re: Geotechnical Tree Planting Recommendations
Proposed Residential Development
245 and 275 LaMarche Avenue – Ottawa, Ontario

date: October 8, 2025

file: PG6152-MEMO.08 Revision 1

ST3

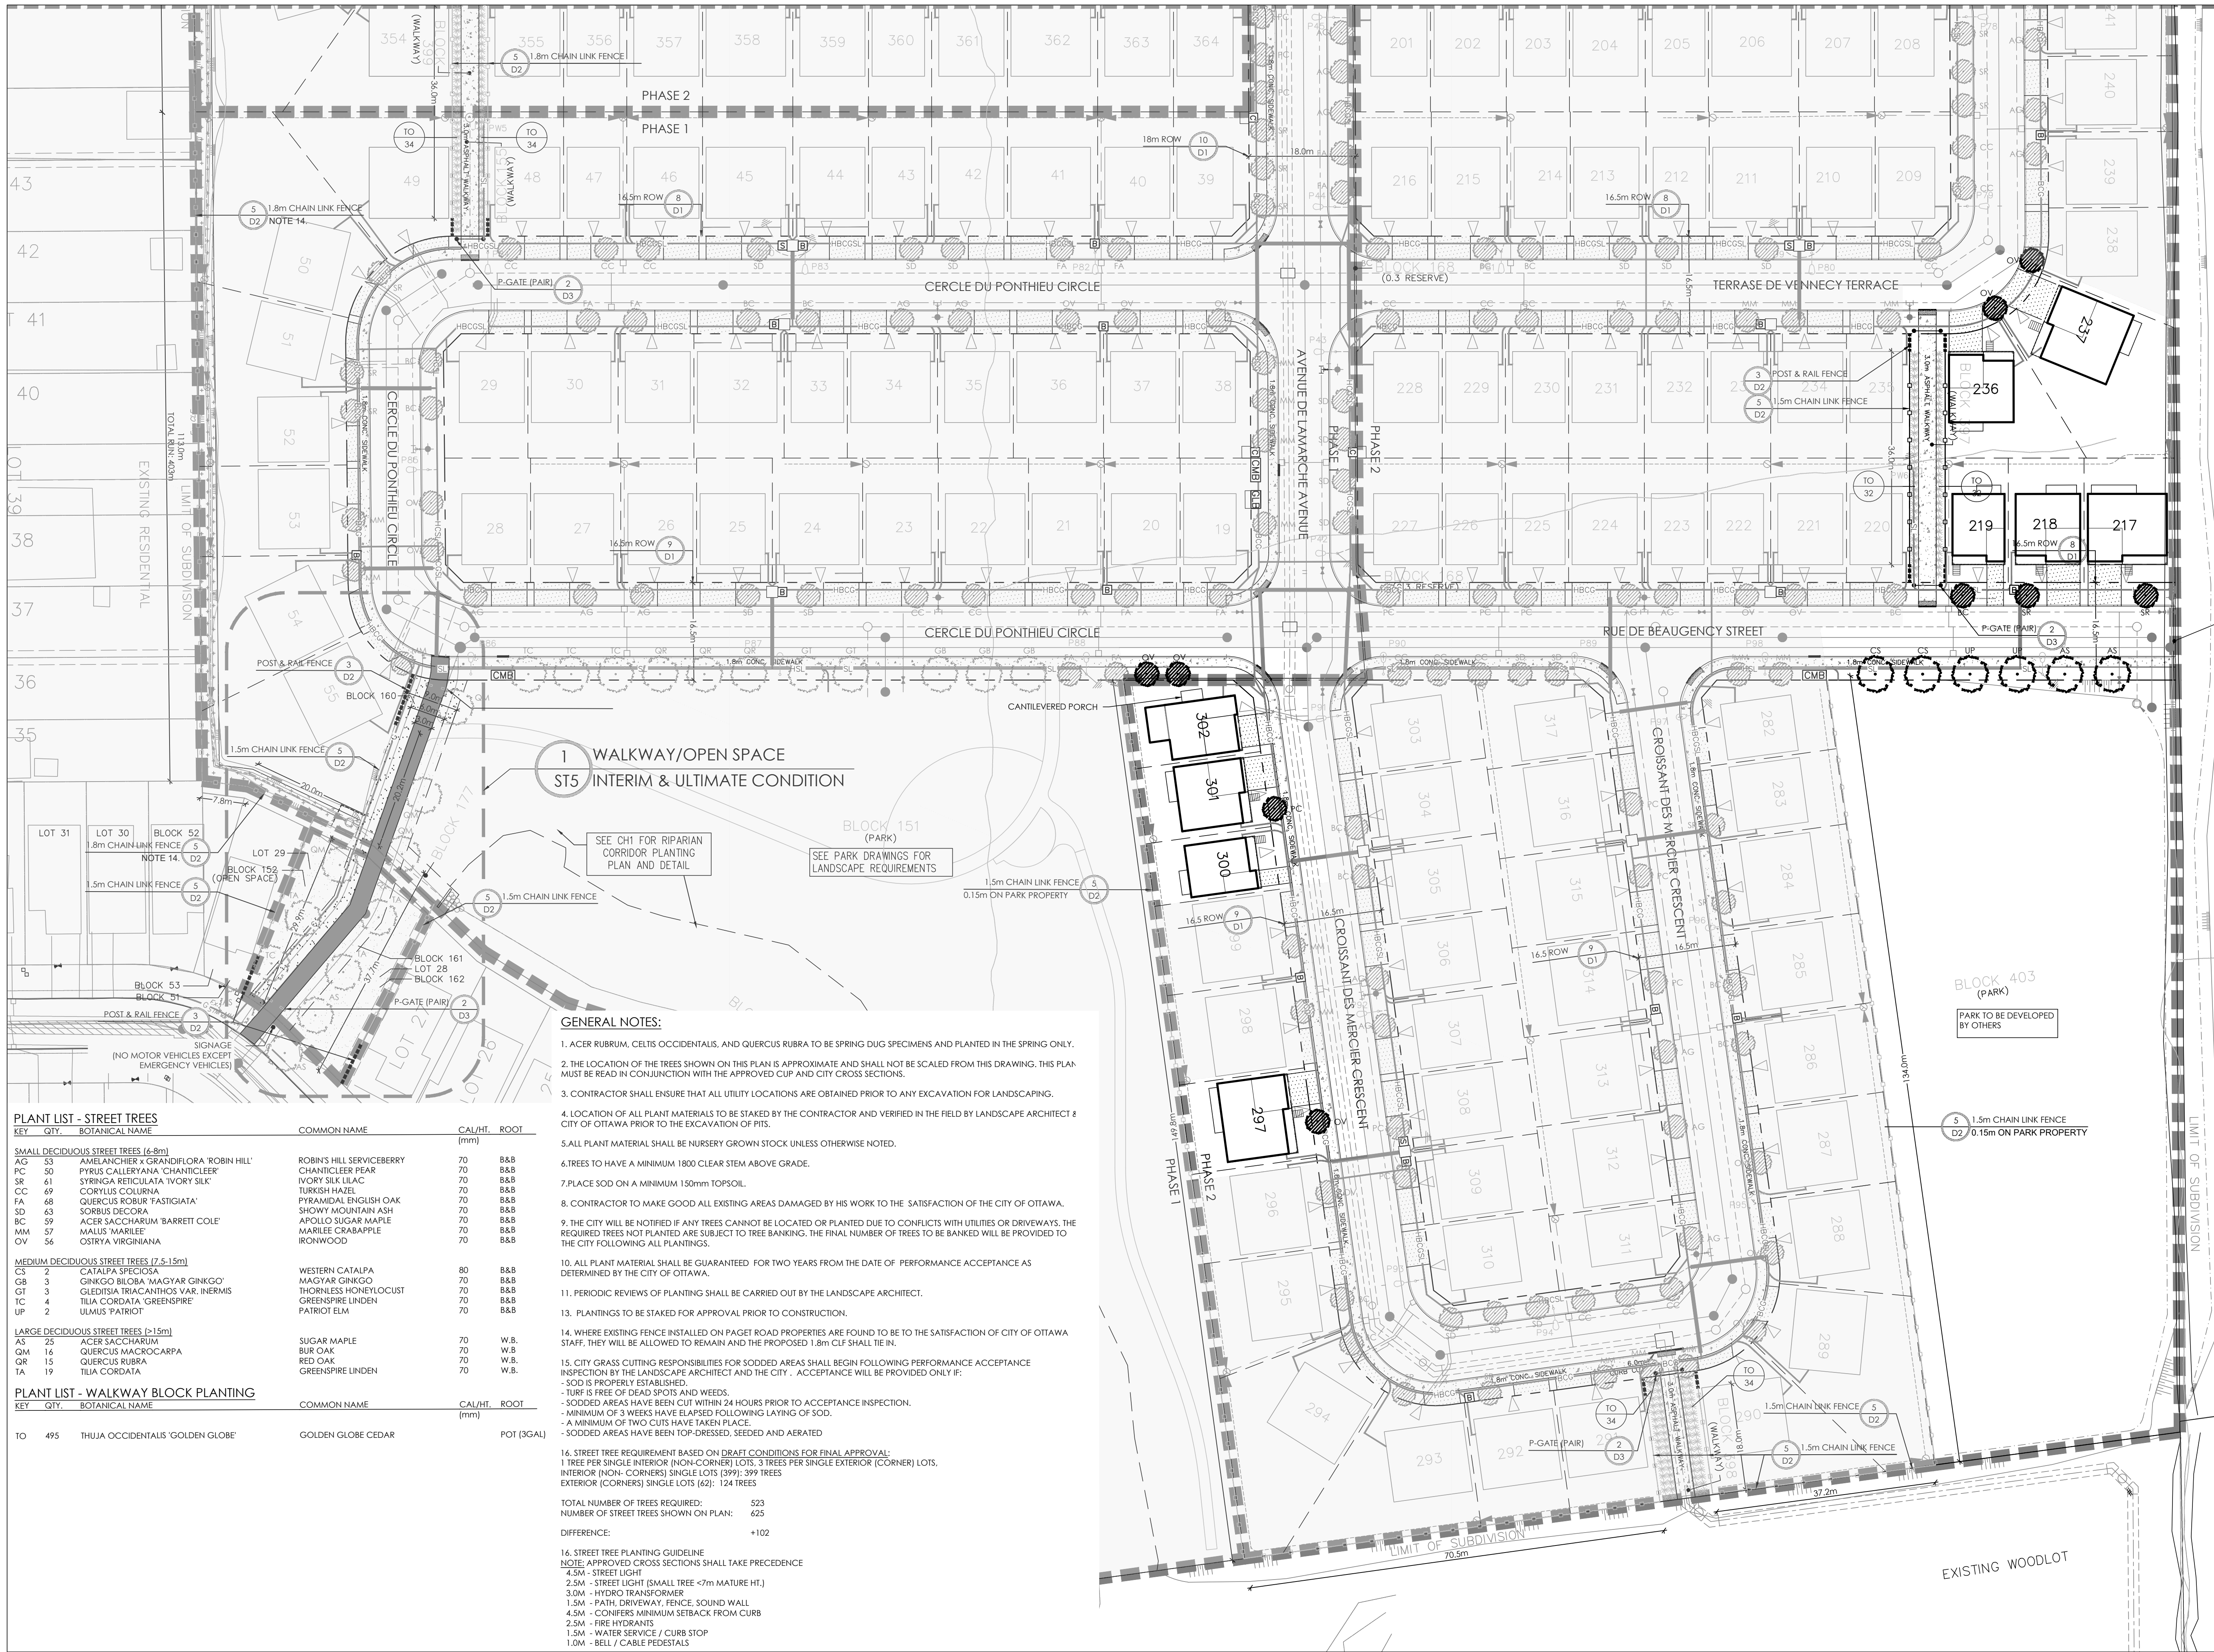
Paterson completed a review of the aforementioned streetscape plan prepared by others. Based on our review, the proposed trees are generally noted to consist of small trees with mature tree heights less than 7 m and were noted to be setback a minimum of 4.5 m away from the foundation of the existing and proposed residential dwellings. As such, the proposed tree planting is considered to be acceptable from a geotechnical perspective.
